From:
Sent: 21 August 2026 16:17
To: DC Admin
Subject: Objection to Planning Application 2026/60/91494/E, Penistone Road, Birdsedge
Attachments: Riverflys from Clayton West upstream.pdf

I object to the above planning application on the fact that surface water drainage will be discharged directly to the River Dearne with no treatment.

Appendix I
Drainage Layout Drawing

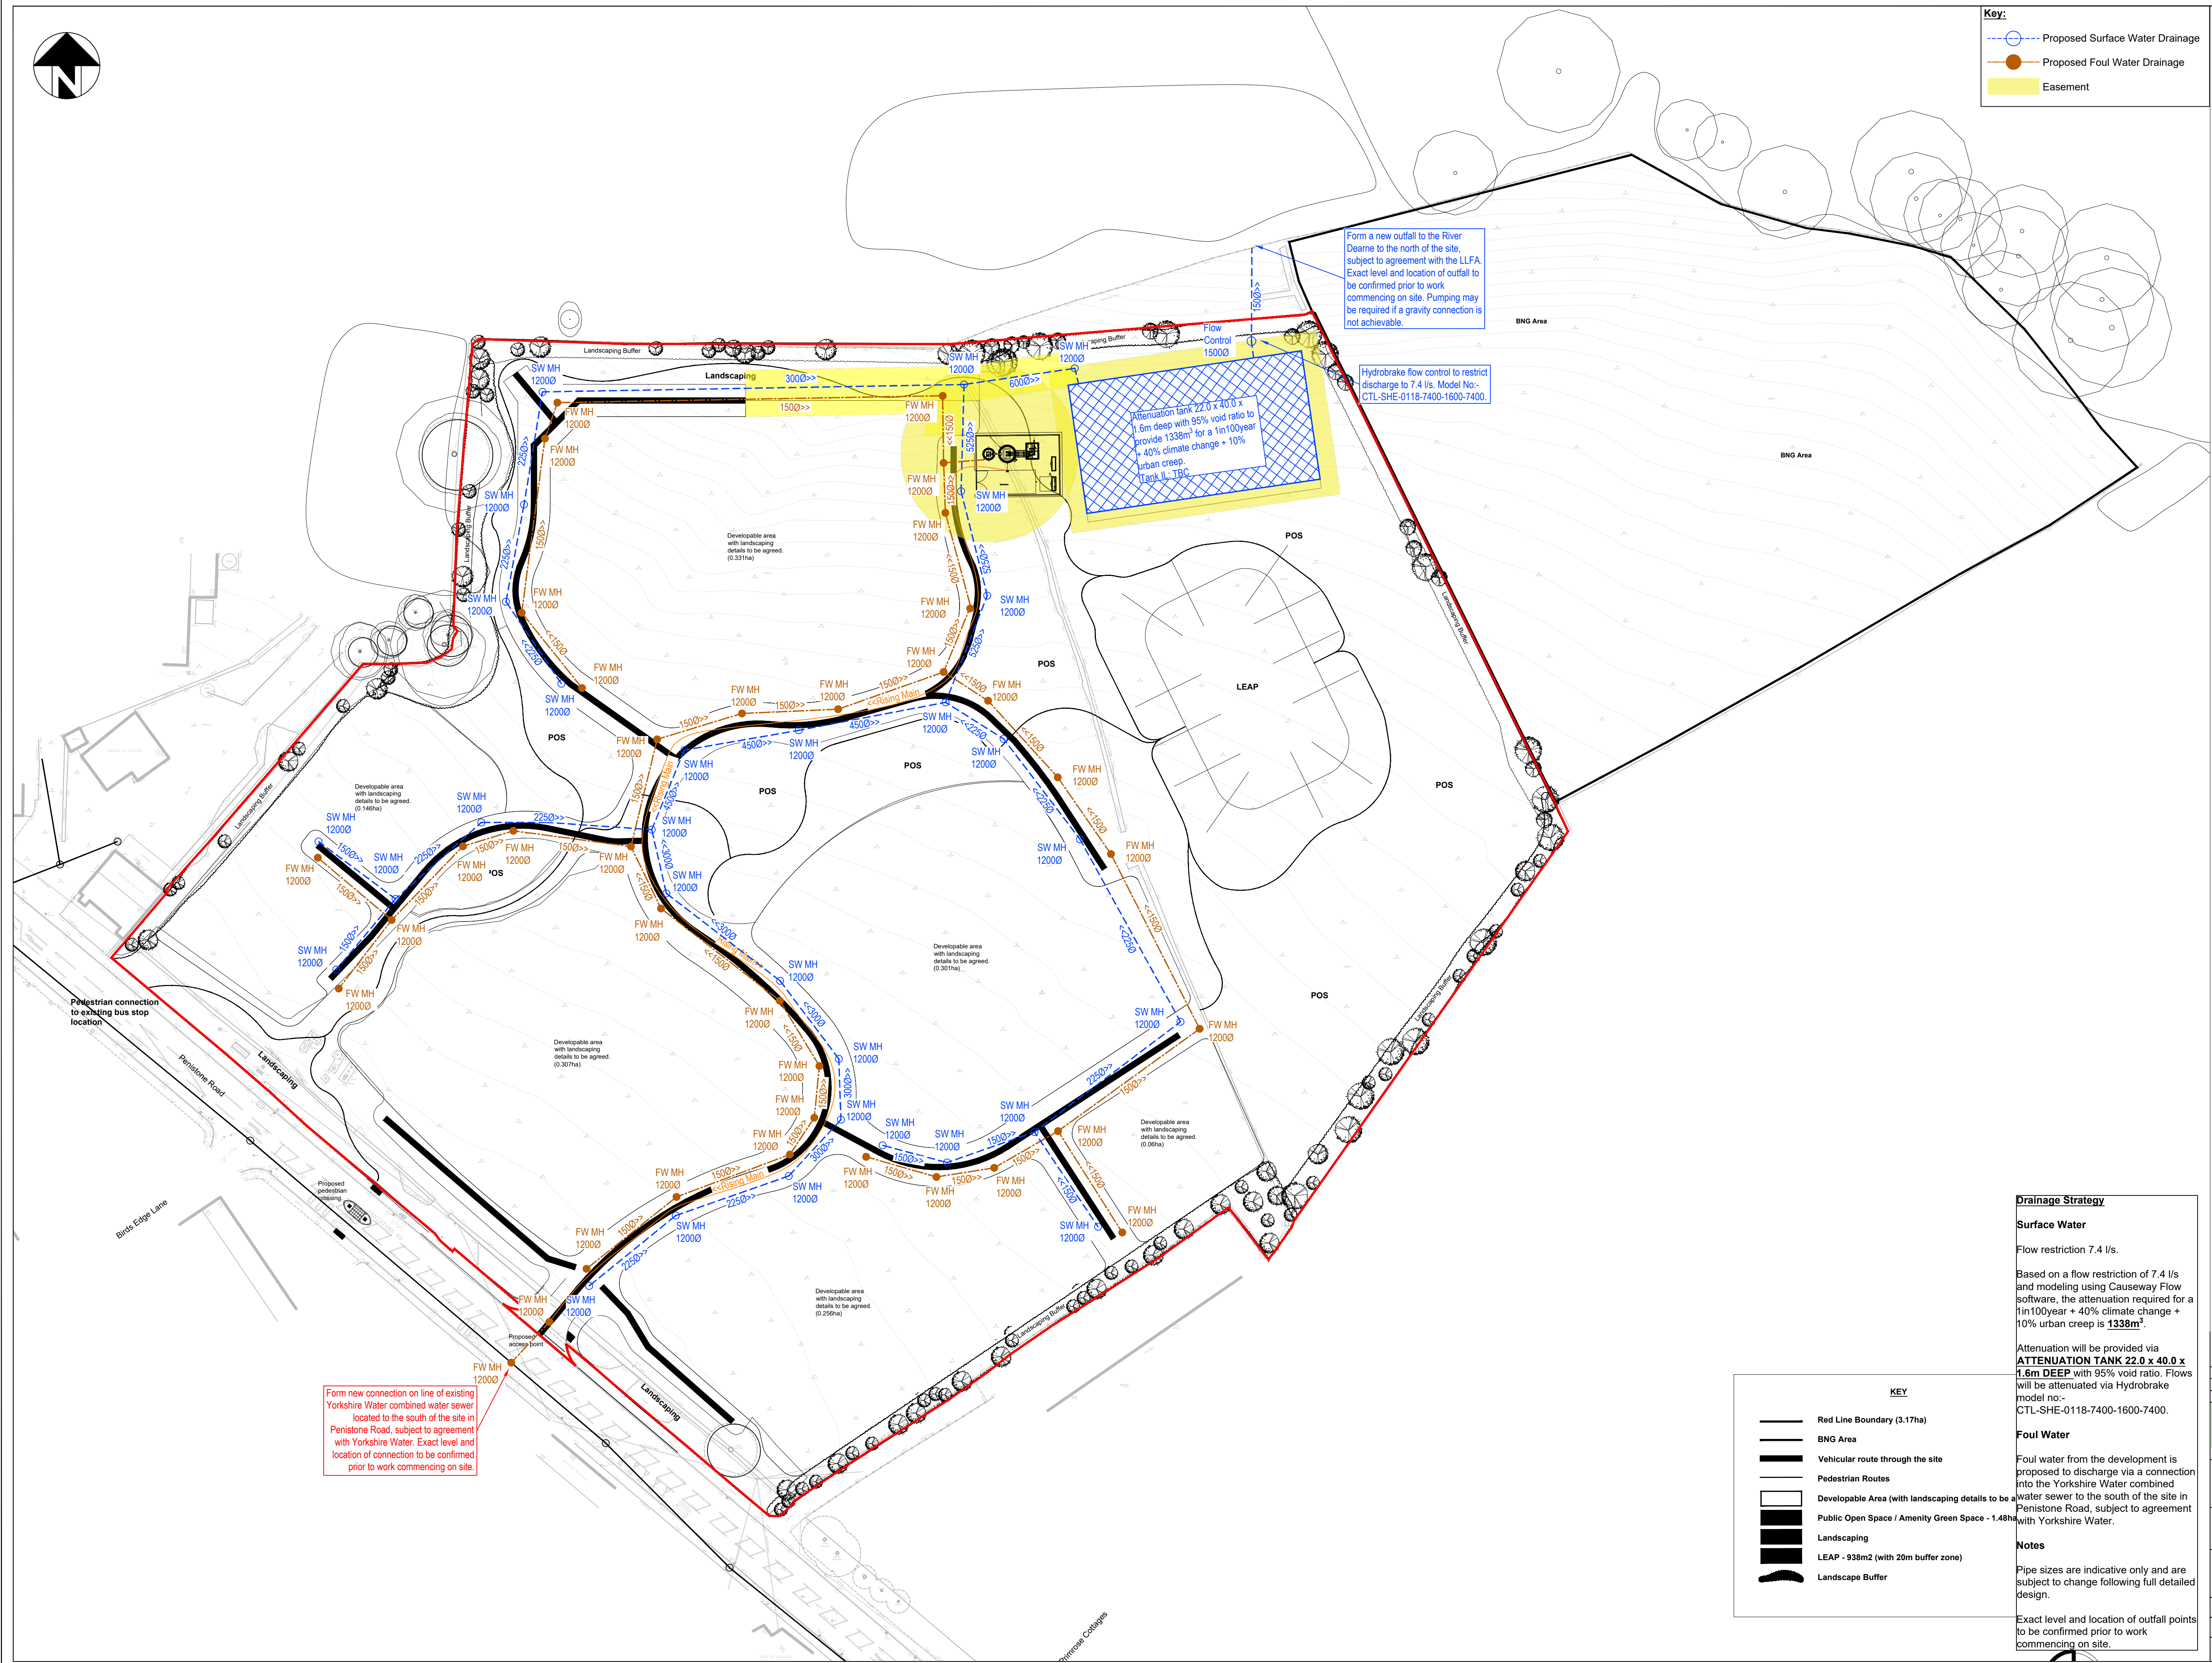
If surface water drainage goes directly to the River Dearne, the pollutants it holds can harm aquatic ecosystems by introducing harmful substances like detergents from car washing, oil, petrol, chemicals, and heavy metals into water bodies, which can smother aquatic vegetation and disrupt the balance of marine life. This contamination can lead to reduced water clarity and negatively affect fish and other organisms such as river flies (which fish feed on), that rely on clean water for survival.

On the basis of the surface water going directly to the River Dearne, I object to this application.
